GROUNDS OF APPEAL

CHEVRON HOUSE, 346 LONG LANE, UXBRIDGE,
UB10 9PF

2.1 The application was submitted on the 10th September 2024 and given reference number 42825/APP/2024/2429. As detailed in the Pre-Amble, the LPA wrote to the Appellant seeking a change of description, removing the elements of the condition that related to drainage, hardstanding and landscaping. On the basis that that detail had been submitted to the LPA to satisfy a Planning Condition. The LPA seemed to have somewhat confused matters here. The Application, as submitted, was seeking full Planning Permission for the retention of / installation of hardstanding, landscaping and installation of a vehicular access. The application form detailed that works had already commenced. The Application was seeking to regularise the works whilst also seeking a dropped kerb, landscaping and drainage detail. The application was not reliant on the condition submissions and the Appellant asserts that the LPA have acted unreasonably in seeking to amend the description of development in the way that they have and at the stage that they requested.

Proposed Vehicle Crossover

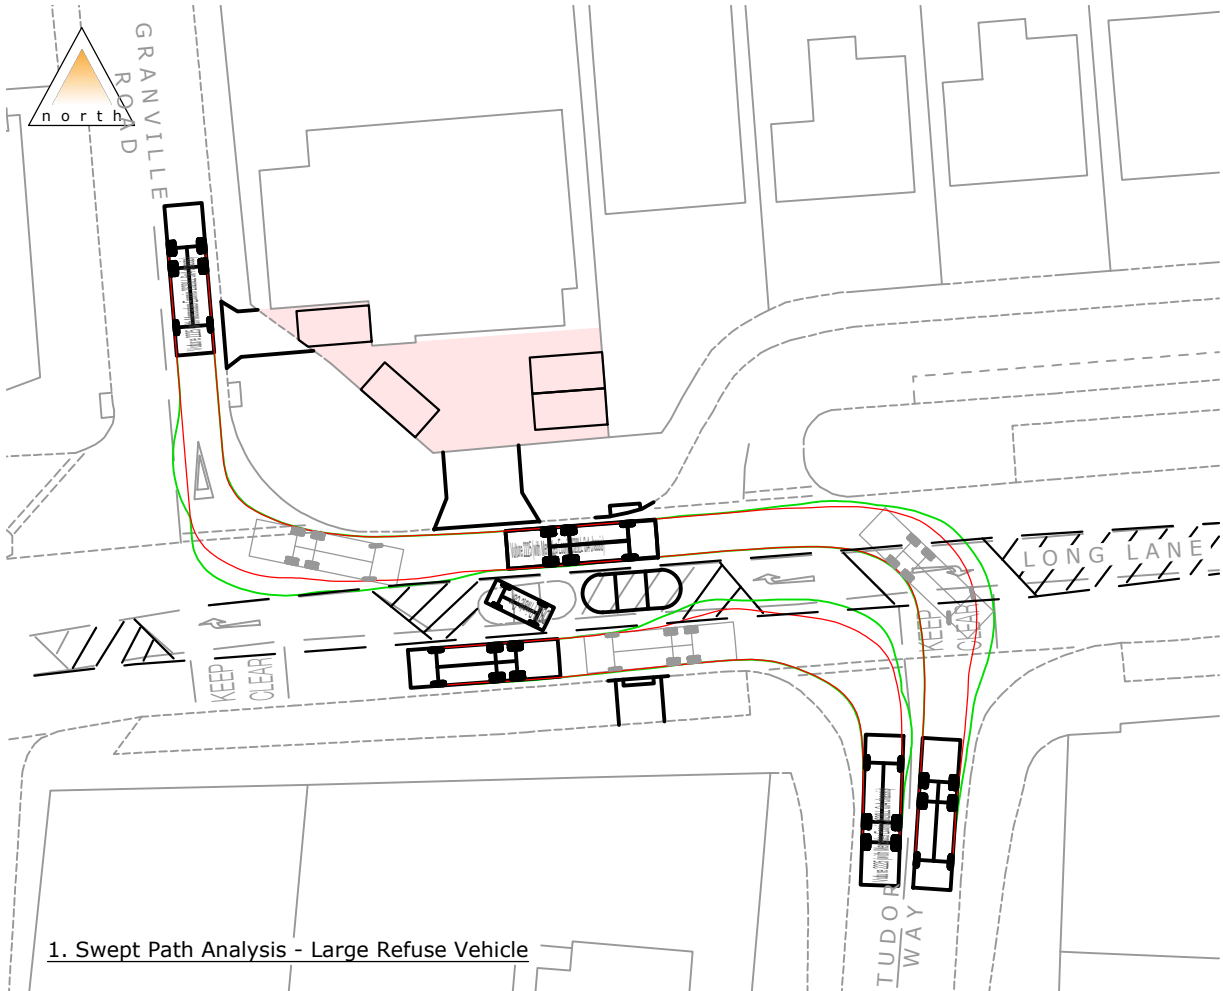
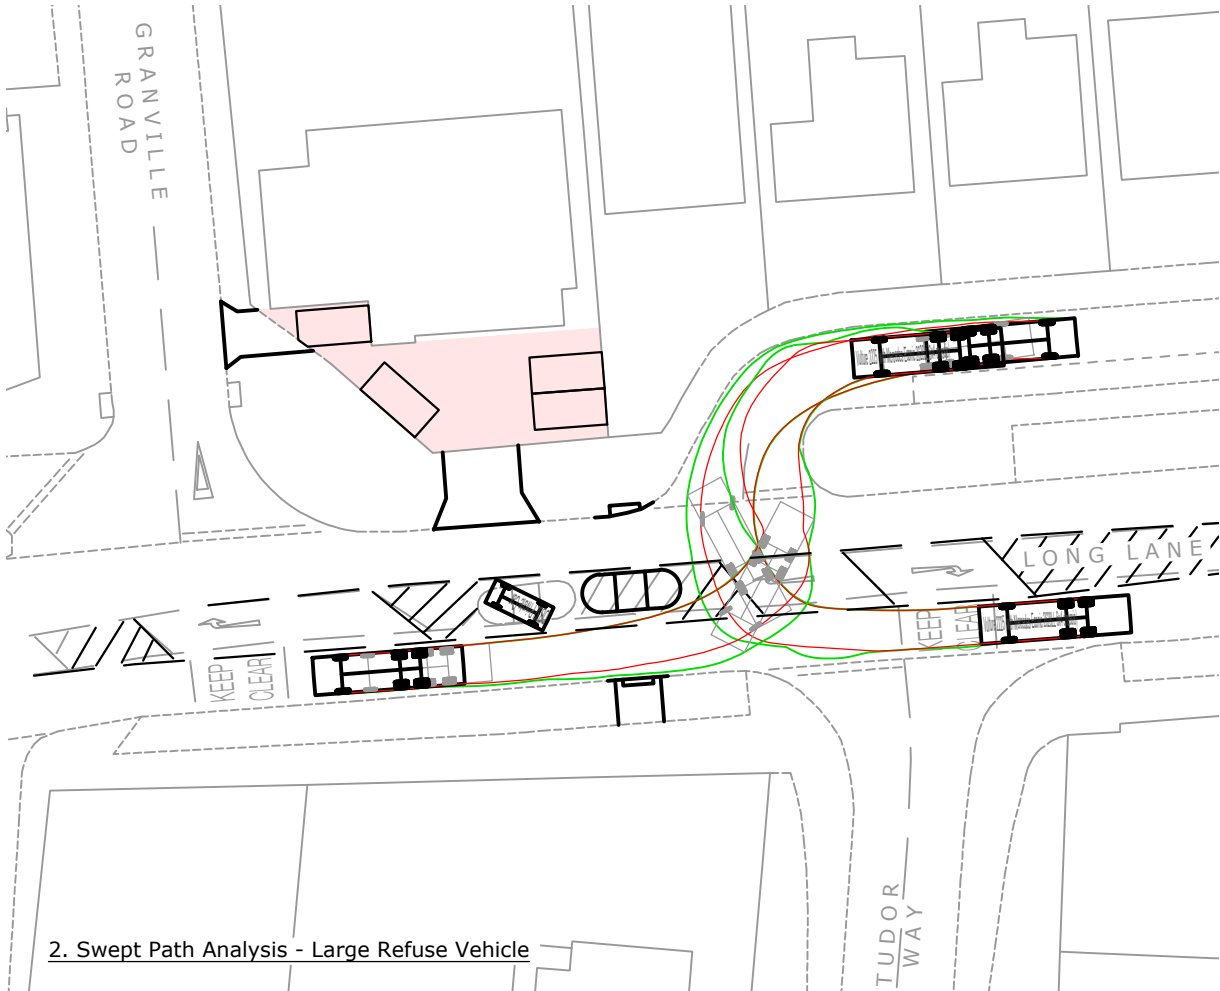
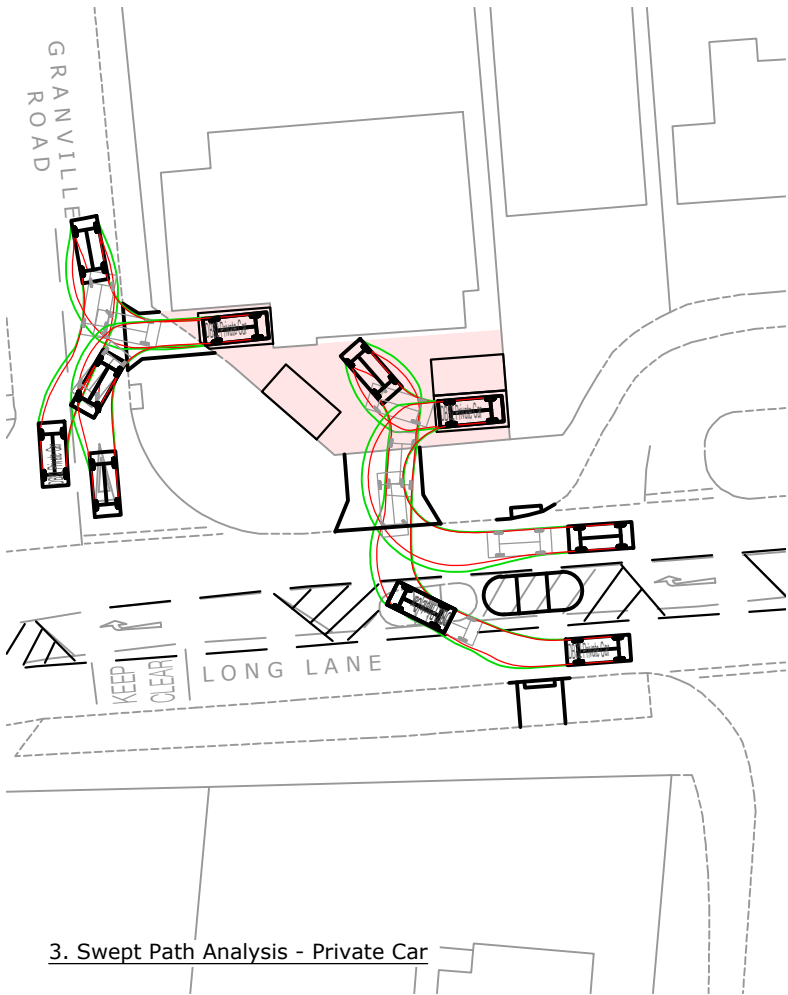
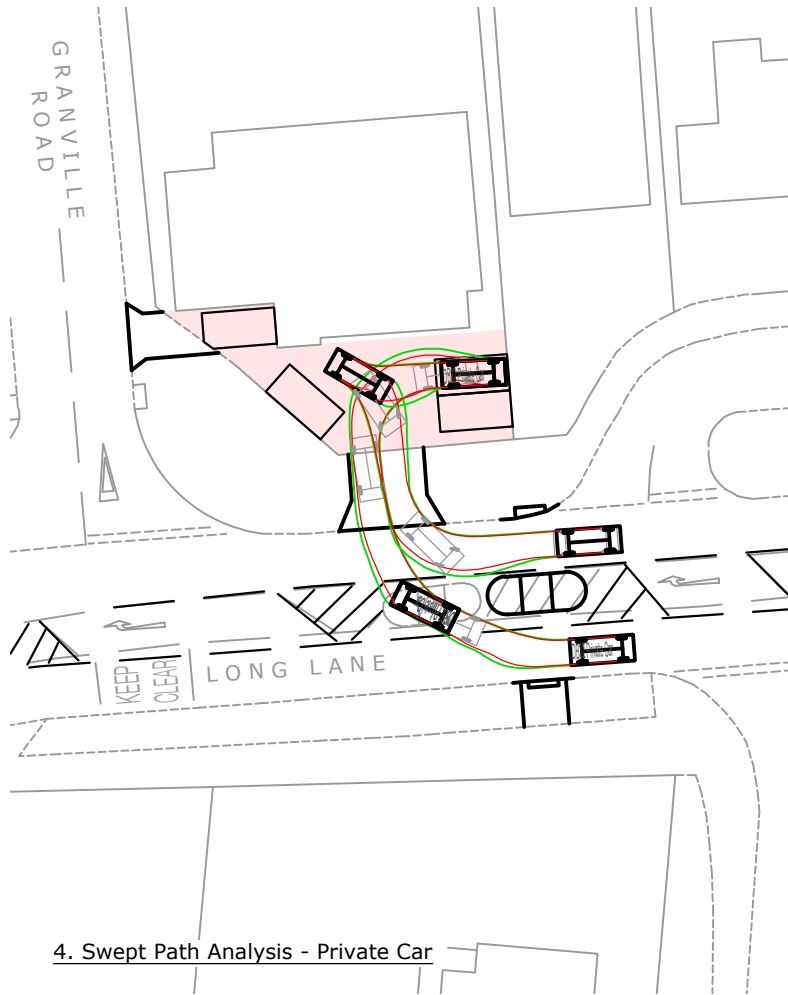
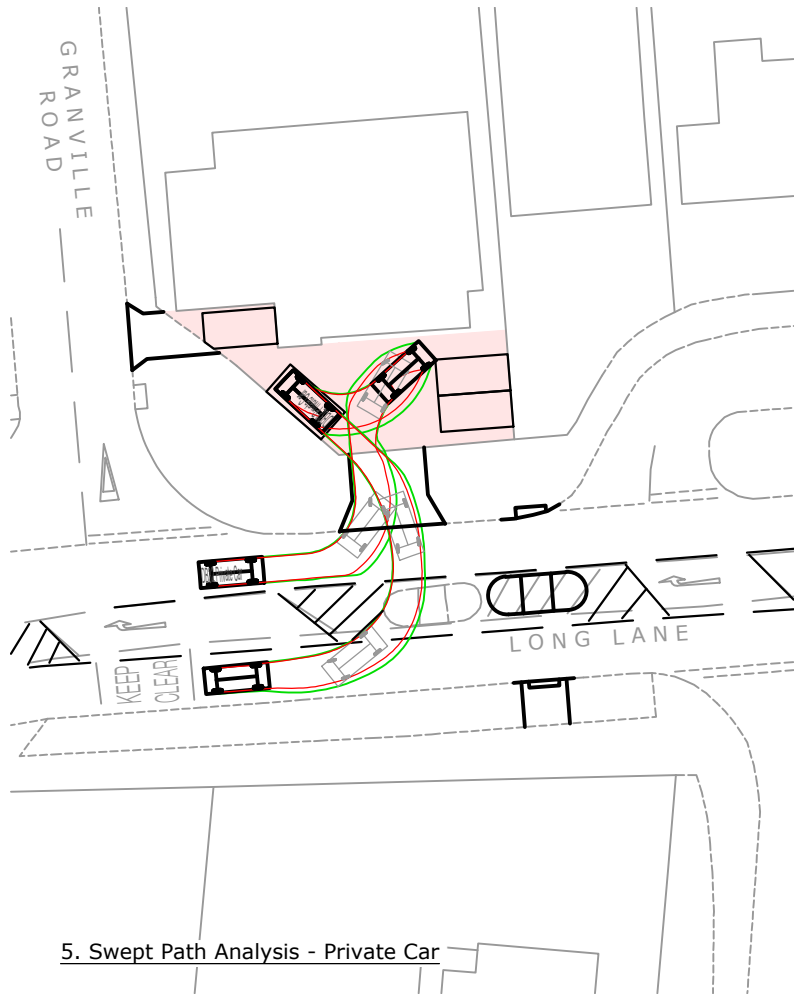
2.2 A single reason for refusal was advanced concerning the application, as detailed below: *“By reason of its size, location, design and surroundings, in particular its proximity to the existing pedestrian crossing, the proposed vehicle crossover raises significant concerns regarding pedestrian and cyclist safety. The proximity of the dropped kerb to the pedestrian crossing introduces an increase in vehicle movements which increase the risk of conflicts between pedestrians, cyclists, and vehicles. The design fails to meet the safety requirements necessary to protect road users, pedestrians and cyclists resulting in significant highway concerns. The proposed development is therefore considered to be contrary to Policy DMT 1 and DMT 2 of Hillingdon Local Plan: Part 2, Development Management Policies (2020) and London Plan (2021) Policies T1, T2 and T4”*. The Application was submitted following a meeting with Highway Officers from the London Borough of Hillingdon. It should be noted that the access seeks a left turn in and left turn out only – signage for such a mechanism can be secured by way of a condition. Previously the office was provided with 2no. off road car parking spaces in addition to the car park at the rear of the premises. The Parking spaces required the reversing out of the space onto Granville Road. Given the amount of unauthorised on-road parking along Granville Road, and the fact that the spaces could not be accessed and egressed in a forward gear, presented a significantly harmful (albeit lawful) experience.

3.1 The development seeks to improve highway safety whilst facilitating safe and level access to the office space. The office is commercially viable and consists of a housebuilder that provides affordable housing, with over 800 new affordable homes under construction. The Office Space is well used, and as a result, more car parking spaces are needed. The application seeks a blend of access needs and landscaping and provides the opportunity to meet the needs of the company. Indeed if the Appeal fails the Appellants will seek to move from the area to find an office space that works for them. This will ultimately result in the demise of the office space in lieu of residential. There are significant amounts on on-road parking issues that prevented the use of the existing spaces, which have been repurposed to provide a bin store. The Appellant suggests that a condition could be imposed seeking highway improvements to facilitate the development, along the lines of plan 2412012 TK01, which shows how a vehicle can access and egress the site without interfering with the local highway network.
